City of Albuquerque Stormwater Construction Site Inspection Report

ESC File No.	L21E045C	Project Name:	Luminaria Senior Community		
NPDES Id. No.	NMR1003H0	Location:	10600 Central Ave.		
6/3/2021	Owner	Contractor			
Operator	Greater Albuquerque Housing Partnership		Jaynes Corp		
Contact name & title	Felipe Rael		Jeff Harper		
e-mail	felipe@abqGAHP.org		jeff.harper@jaynescorp.com		
Contact Phone #	505-980-5922		505-250-9351		
COA Inspector	Thomas Evans		Start/End Time:	1:10 PM-1:35 PM	
Construction Phase:	Vertical				
Type of Inspection:	Regular	Storm Event	Past Storm Event >0.25"	311/Complaint	Follow Up
Weather at time of inspection?	clear		Temperature:	~ 84	
Estimated date of last storm 0.25" or greater	5/31/2021

ESC-1

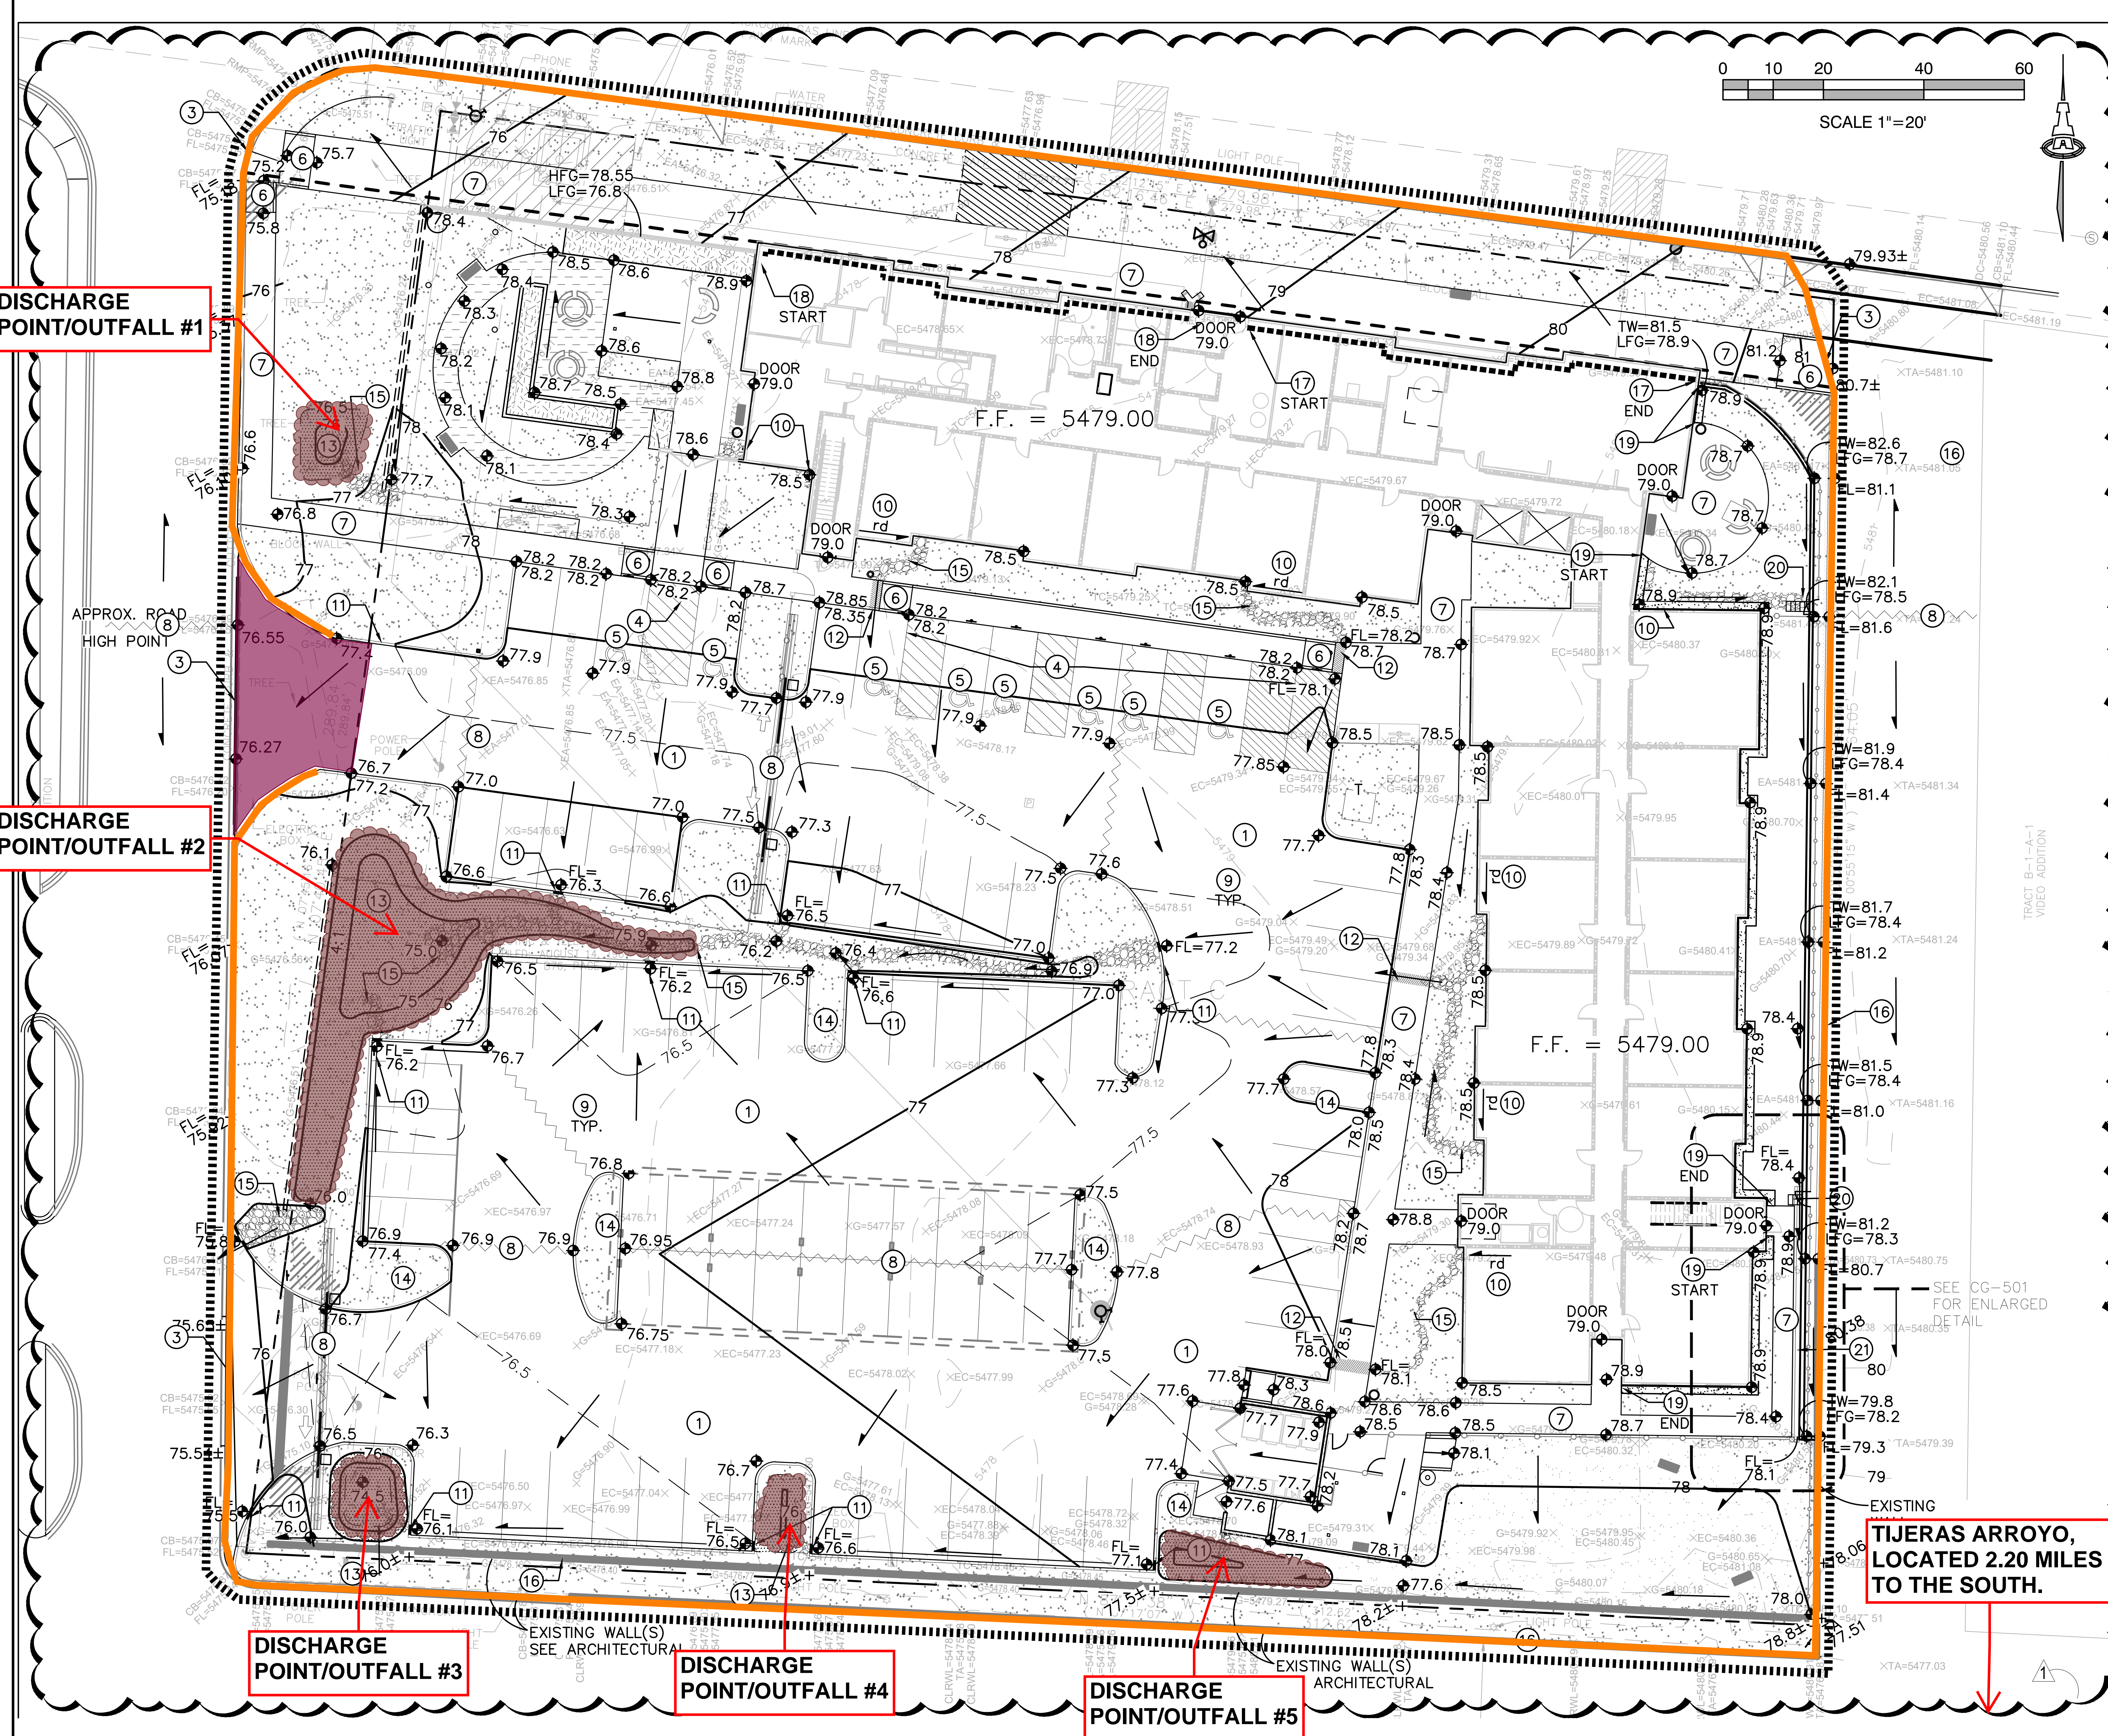
Item Number	Deficiency/ Corrective Action				
1	Track-out pad needs maintenance. Add additional rock to track-out pad				
2	No perimeter BMP along North fence line. Install perimeter BMP as described in the ESC plan.

Notes:	Jeff said that the track-out pad is scheduled for maintenance next week and that he will re-install the perimeter BMP on the North side.
